## Comments on the Applicant's D1 Submissions

This document sets out the comments by Cambridgeshire County Council (**CCC**) and Fenland District Council (**FDC**) (together, **the Councils**) on the Applicant's Deadline 1 (**D1**) submissions. The tables below set out the document in question that the Councils are commenting on, together with the relevant paragraph or reference number.

**Figure 10.1i**  
**New Bridge Lane access design**

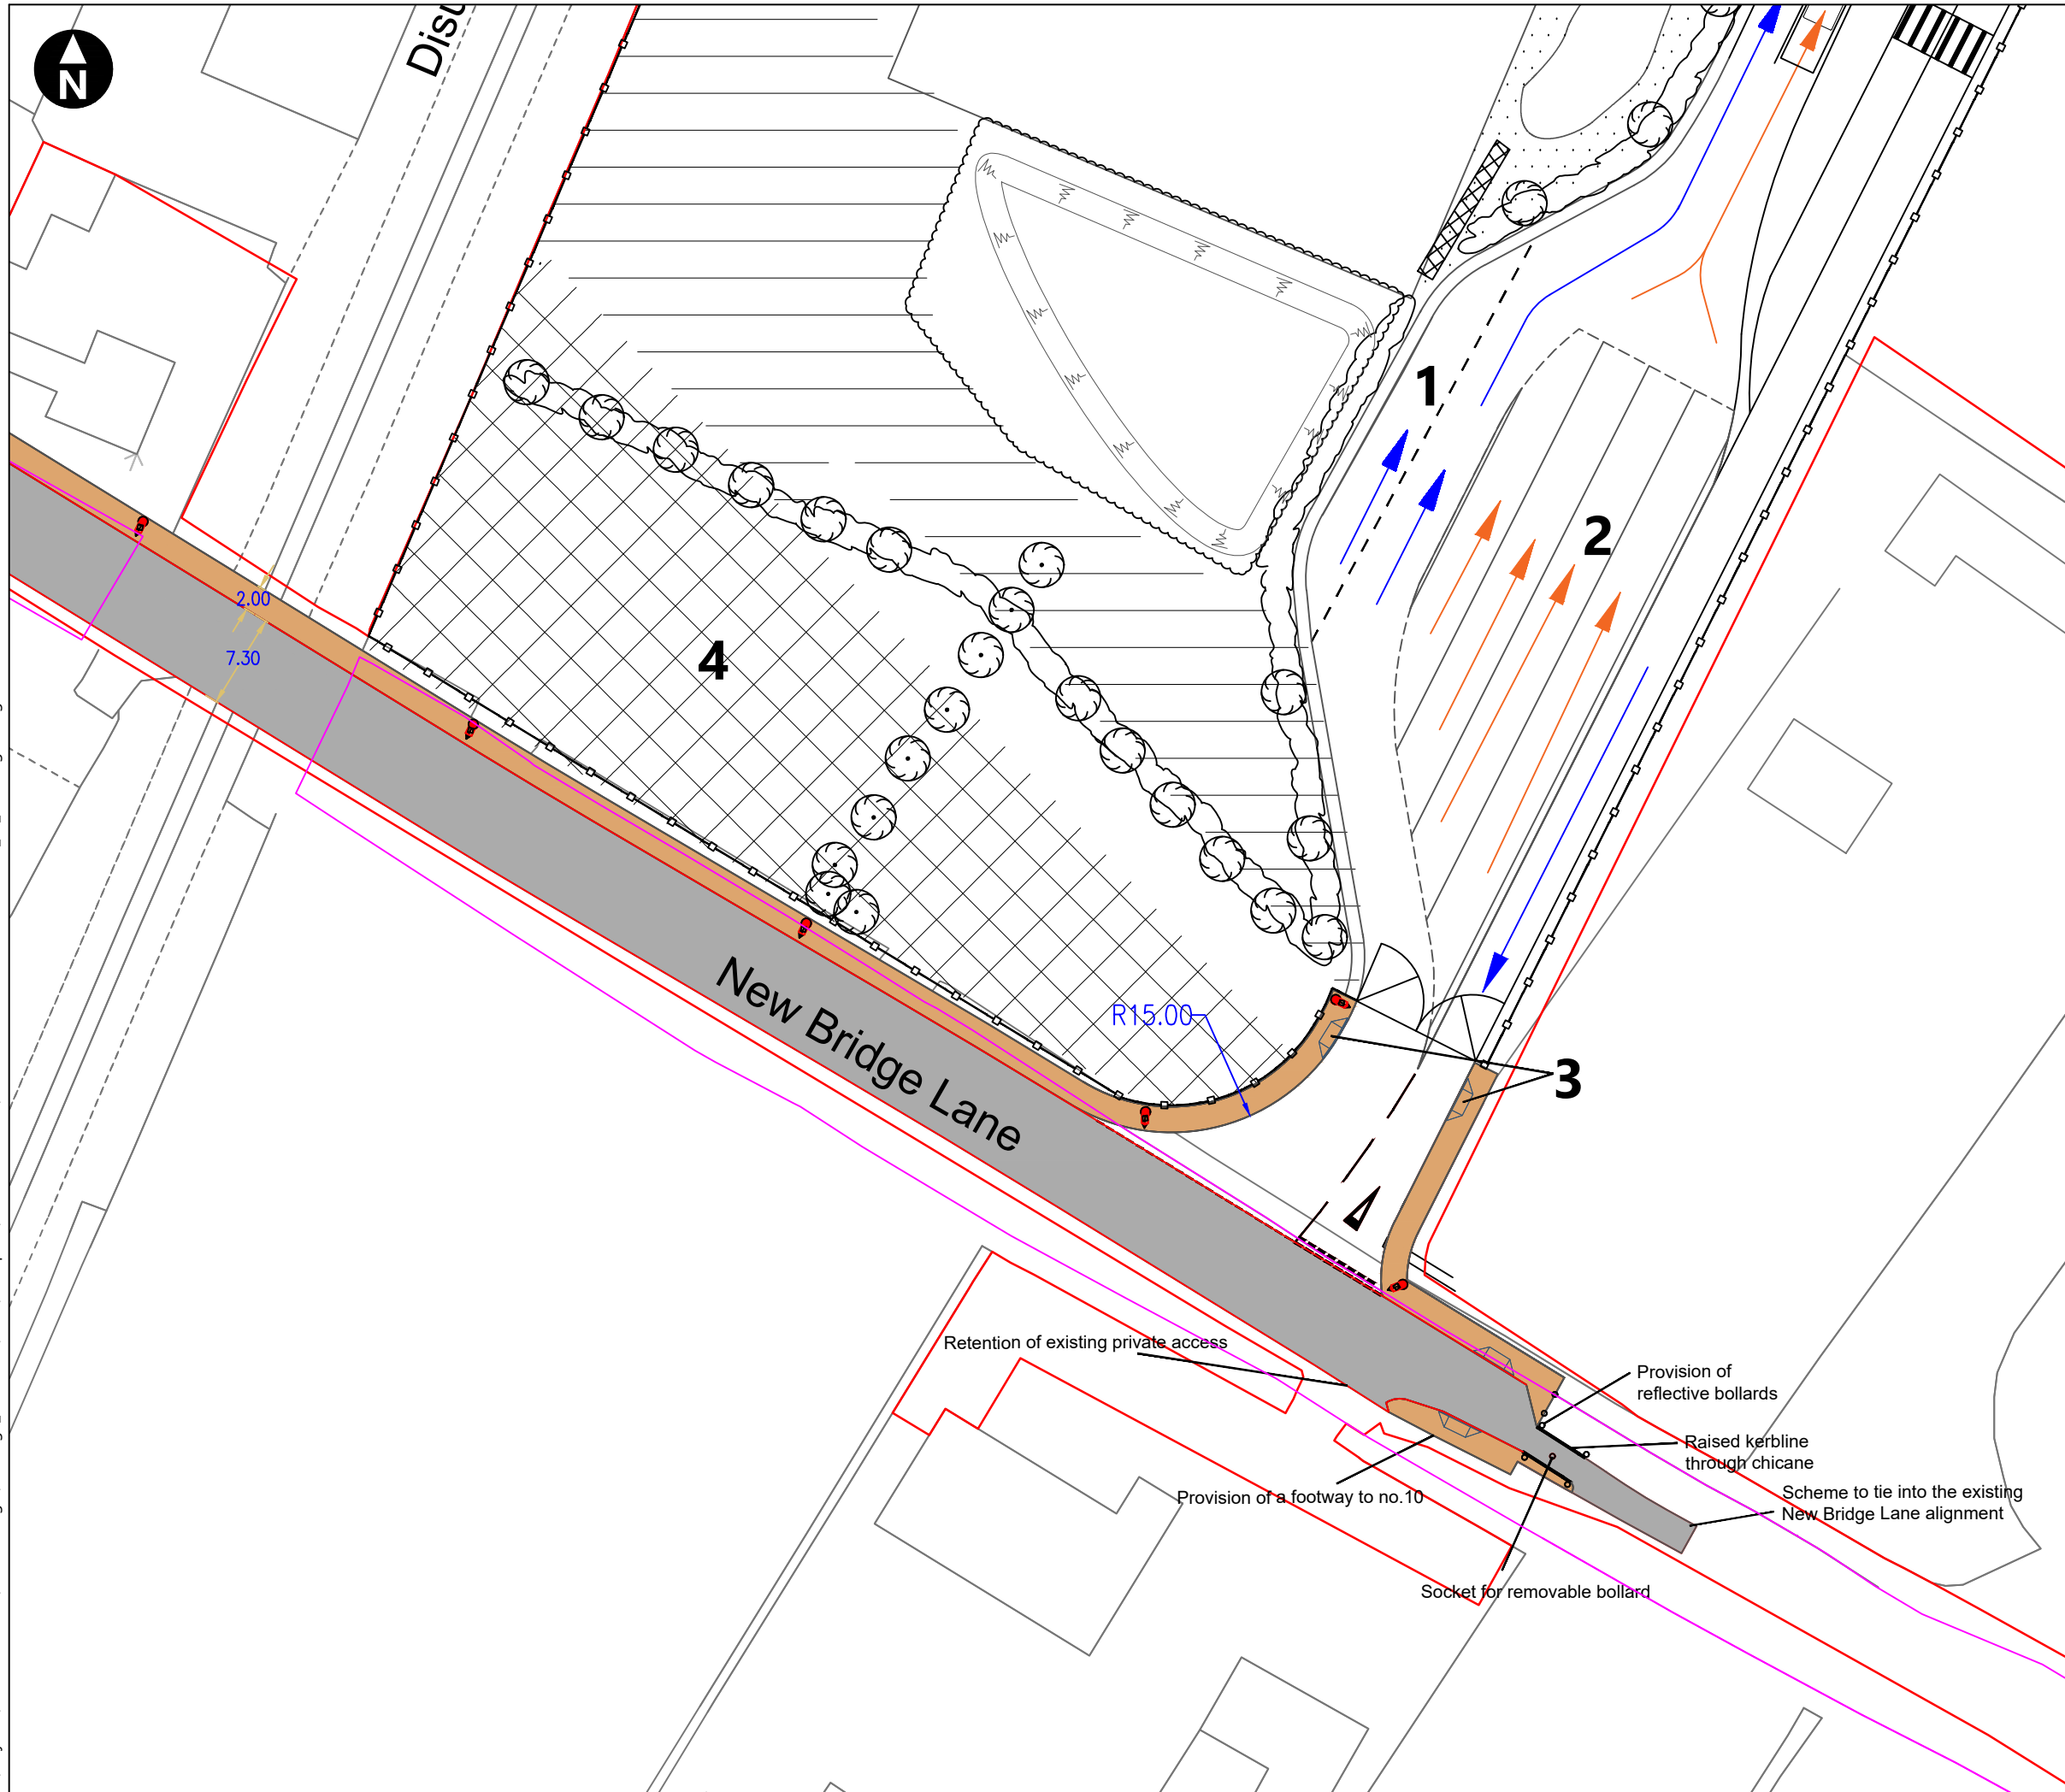
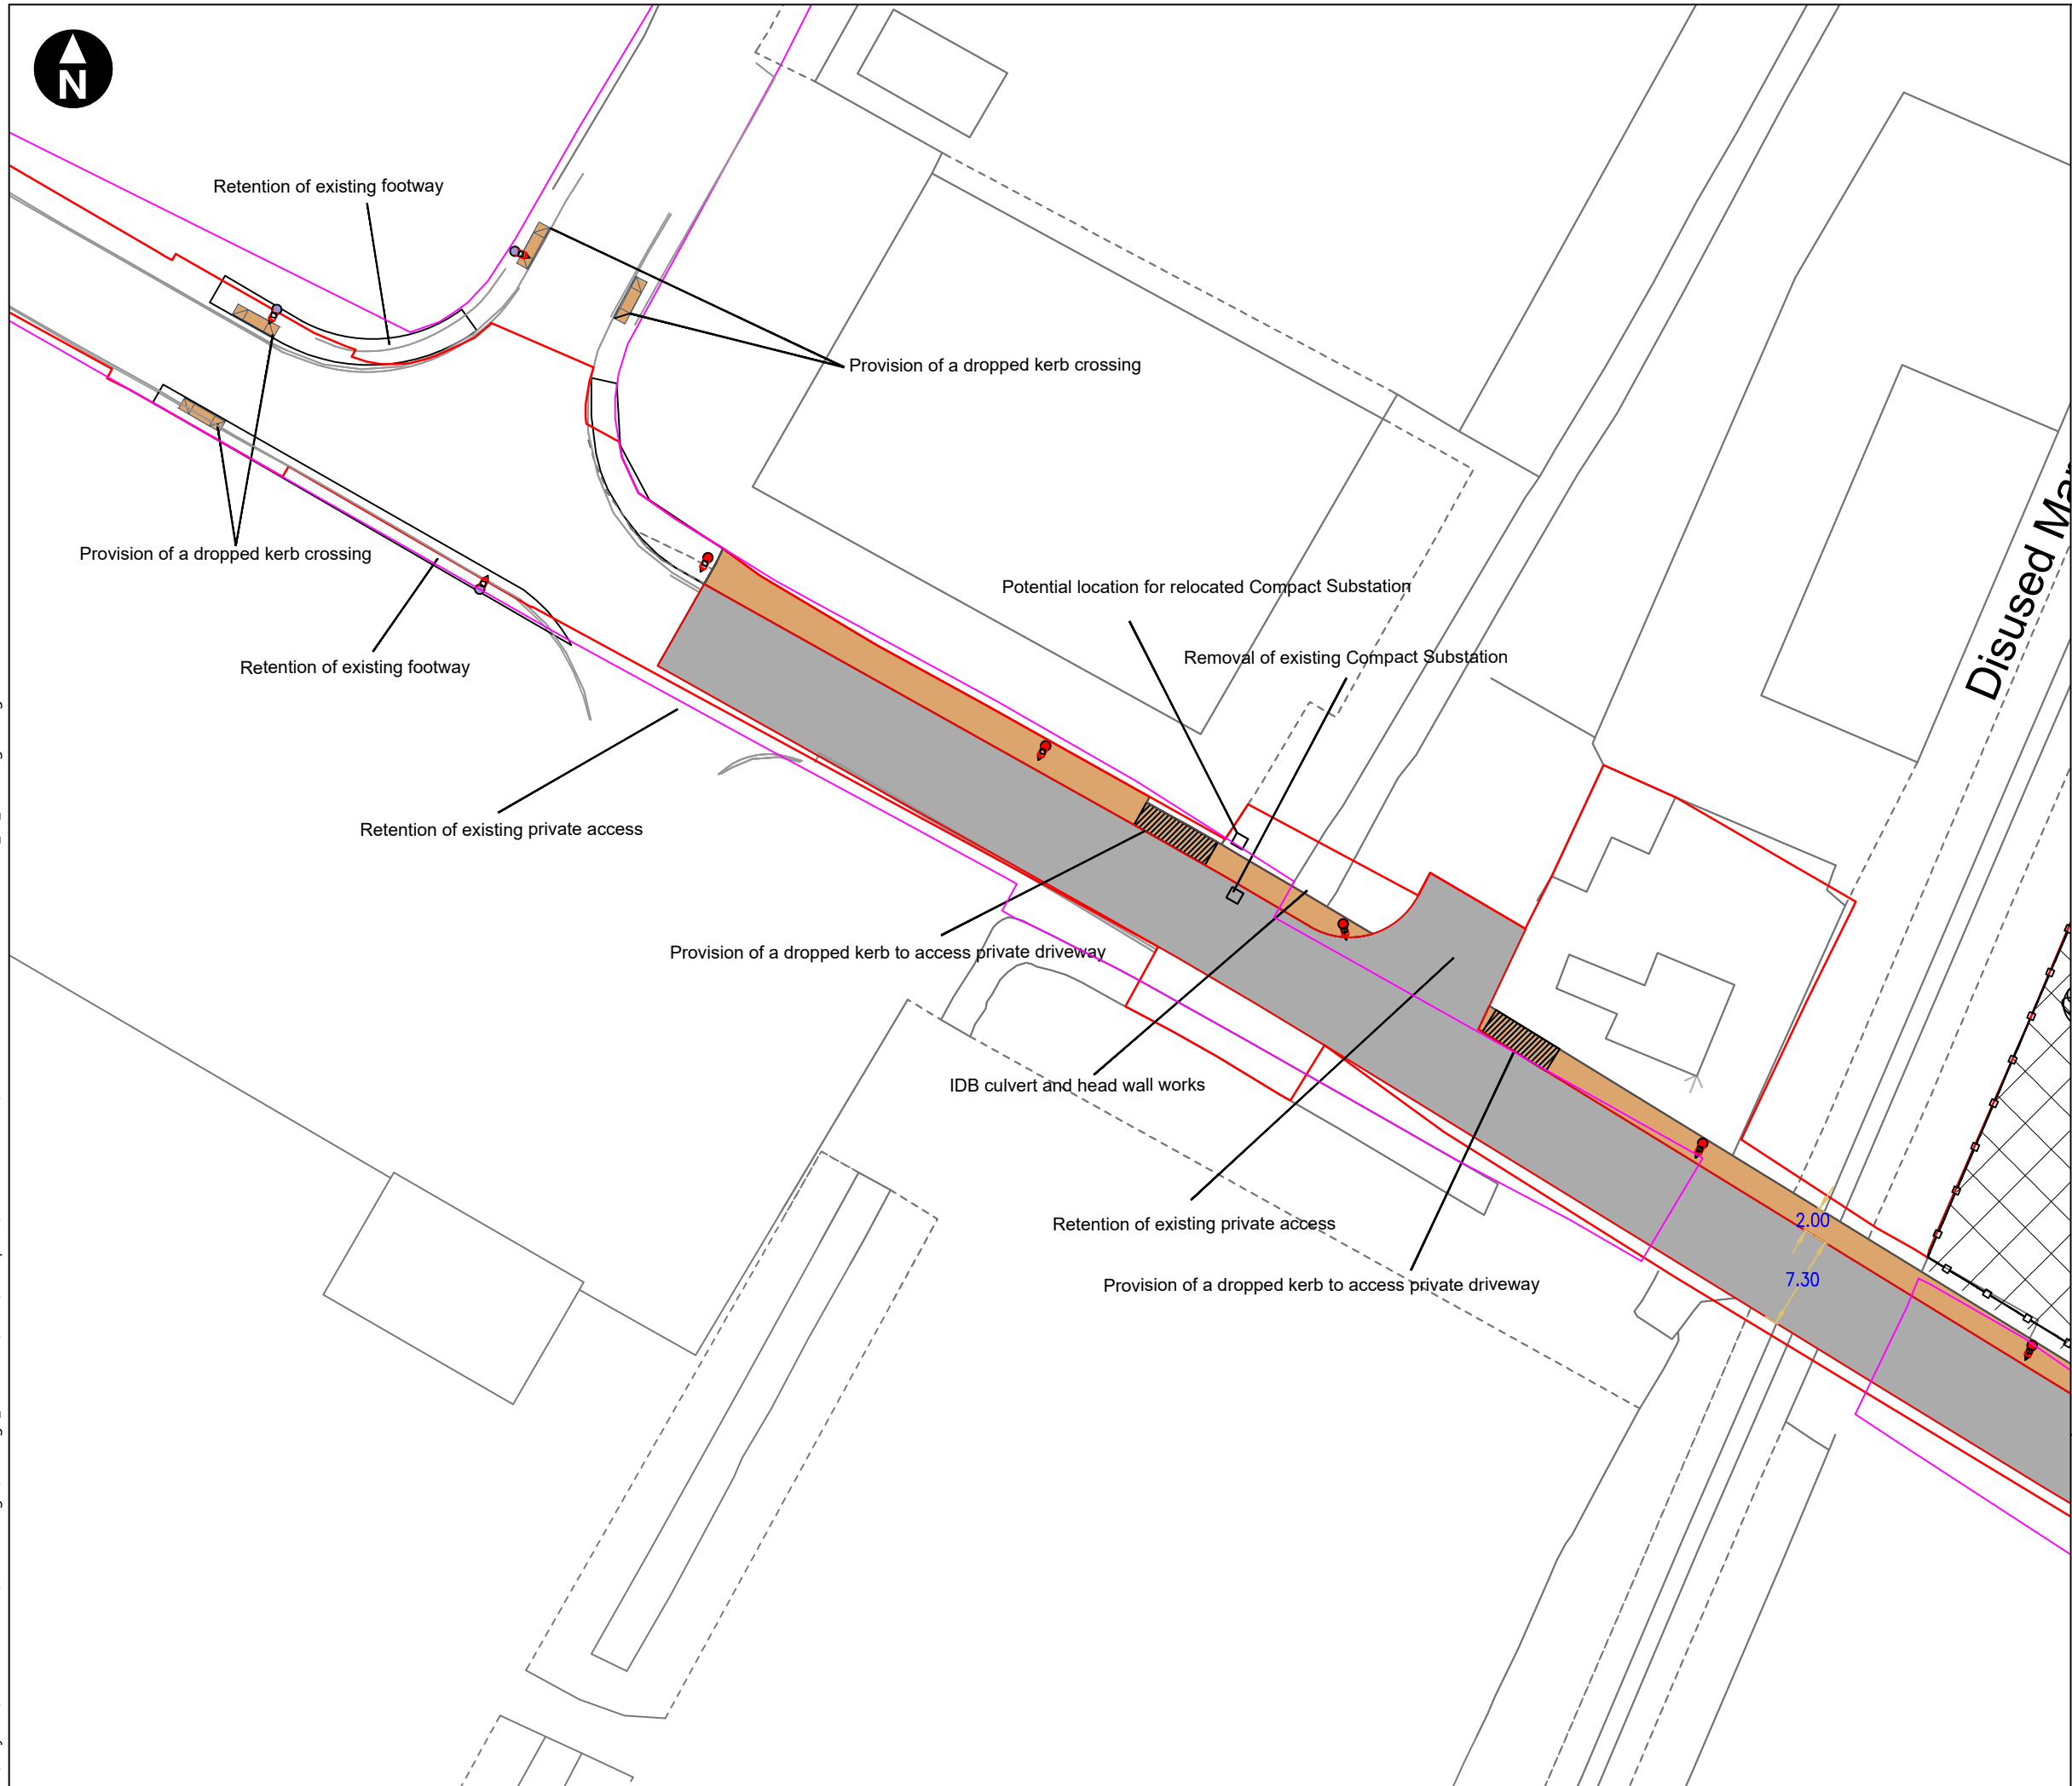
Topic	Paragraph Number	Councils' Comment
Non-motorised users	General	The Outline CTMP does not provide any detail on how access will be preserved for non-motorised traffic that uses New Bridge Lane and the former level crossing as a through route. The Councils request that detail is provided on this.
Damage to highway network	General	<p>The outline CTMP does not address the issue of damage to the wider highway network for which CCC is responsible. It is noted that there is provision for the inspection of access points to the highway to be used by construction vehicles.</p> <p>It is requested that provision be made for “before”, “during” and “after” inspections of the wider highway network to be affected by construction traffic. The methods of these inspections are to be agreed with CCC and the inspections funded by the Applicant.</p> <p>It is further requested that provision be made for the Applicant to fund any highway maintenance works that are required to remedy damage caused by construction traffic to the wider highway network.</p>
